| Consultation Response from KC, Conservation and Design | | |
| 2020/91919 The Co Operative Food, 19, Northgate, Almondbury, Huddersfield, HD5 8RX | | |
| Demolition of existing supermarket and erection of block of 6 flats with associated parking (within a Conservation Area) | | |
| Date Responded: 27.9.21 | Responding Officer: Sue Brooks | Responding Ref: |

SHEET NAME: PROPOSED ELEVATIONS

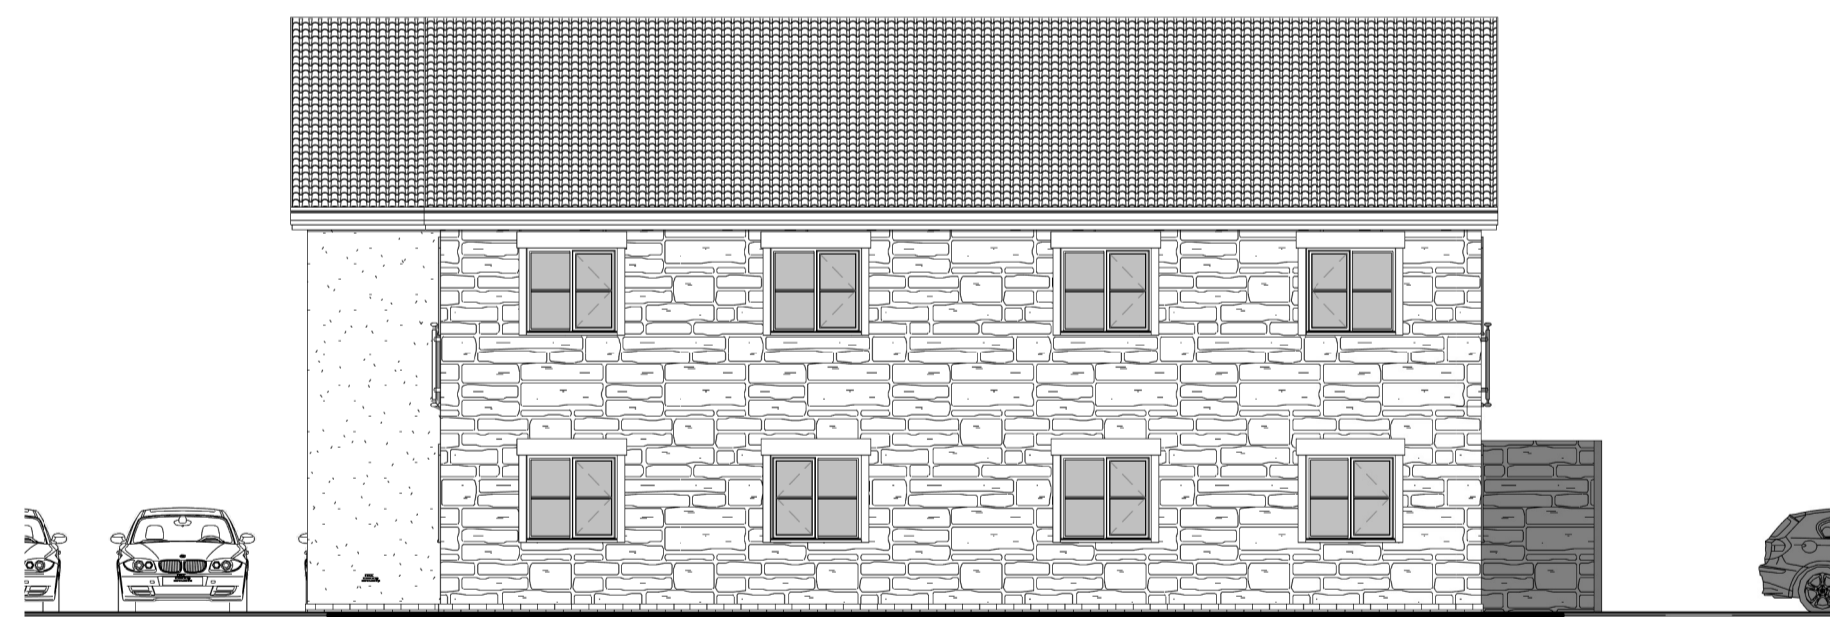
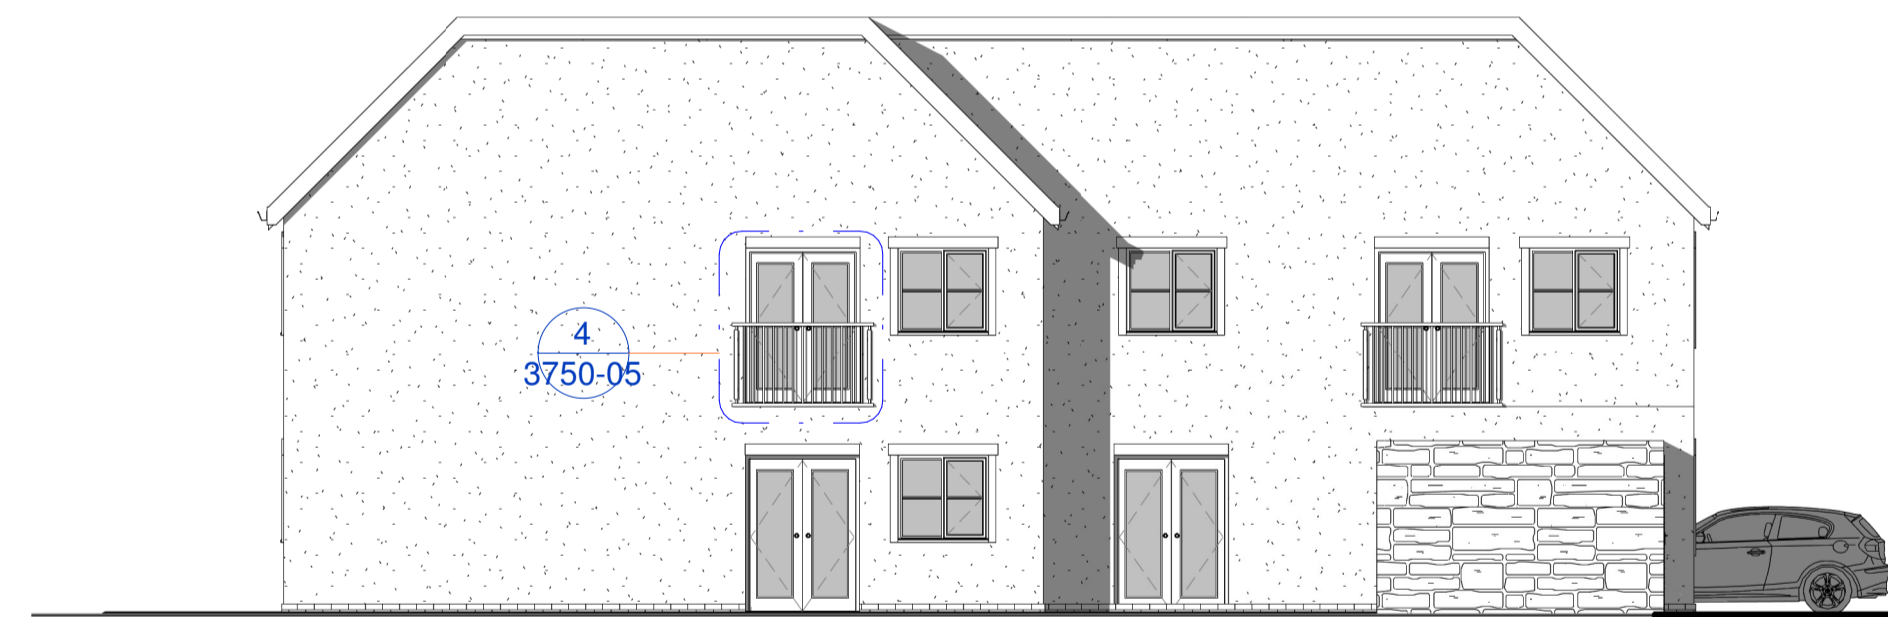
| <p>Following receipt of amended plans, the Conservation and Design Team have the following comments:</p> <p>The revised drawings show a two-storey building which we consider to be acceptable as this reflects the height of most buildings within its setting. However, the revisions do not address our previous concerns. The design of then building, with truncated gables, flat roofs and extensive render, does not reflect the character of the surrounding buildings and conservation area, with the prominent south-east elevation being particularly harmful.</p> <p>As before, we support the use of natural stone, but no details have been submitted, including the finish and type of stone, window surround details or gutter corbels. The extensive use of render is not characteristic of the area and should be omitted on the prominent elevations and reduced or omitted on the less prominent elevations.</p> <p>The window design on the façade has been improved, although limited detailing has been submitted and this elevation still retains large areas of blank walling and a lack of interest. Simple iron railing balconies have been proposed instead of glass balustrades and this is an improvement.</p> <p>The design and access statement considers the building to be in keeping with the local area, providing an enhancement, but it does not elaborate on this or give justification for the extensive use of render, the use of truncated gables and flat roofs. The character of the surrounding area does not appear to have been explored and considered sufficiently in this proposal.</p> <p>LP35 states that ‘proposals shall maintain local distinctiveness’ and LP24 states that ‘the form, scale, layout and details of all development shall respect and enhance the character of the townscape, heritage assets and landscape’.</p> <p>The heritage statement notes that the proposal will not cause substantial harm to the heritage assets, and I would agree with this. However, it also states that the proposed scheme will have no impact on the conservation area or nearby listed buildings and will fit seamlessly within the conservation area. Although it is an improvement on the existing building, the design and layout lead to less than substantial harm to the character of the conservation area by the use of render, the design of the visible elevations and the roofline, along with the expanse of tarmac on the front boundary which does not create an attractive street scene. The proposal does not respect or enhance the character of the townscape or the setting of the nearby listed buildings.</p> <p>This is a good opportunity to enhance a prominent site within the conservation area and there are clearly public benefits in providing housing and improving this site, and I support a residential scheme in principle. However, the design of the building should be amended to reflect the local character, with the layout of the site re-designed to reflect the surrounding street scene and character.</p> <p>The Conservation and Design Team are unable to support this proposal in its current form.</p> | | |
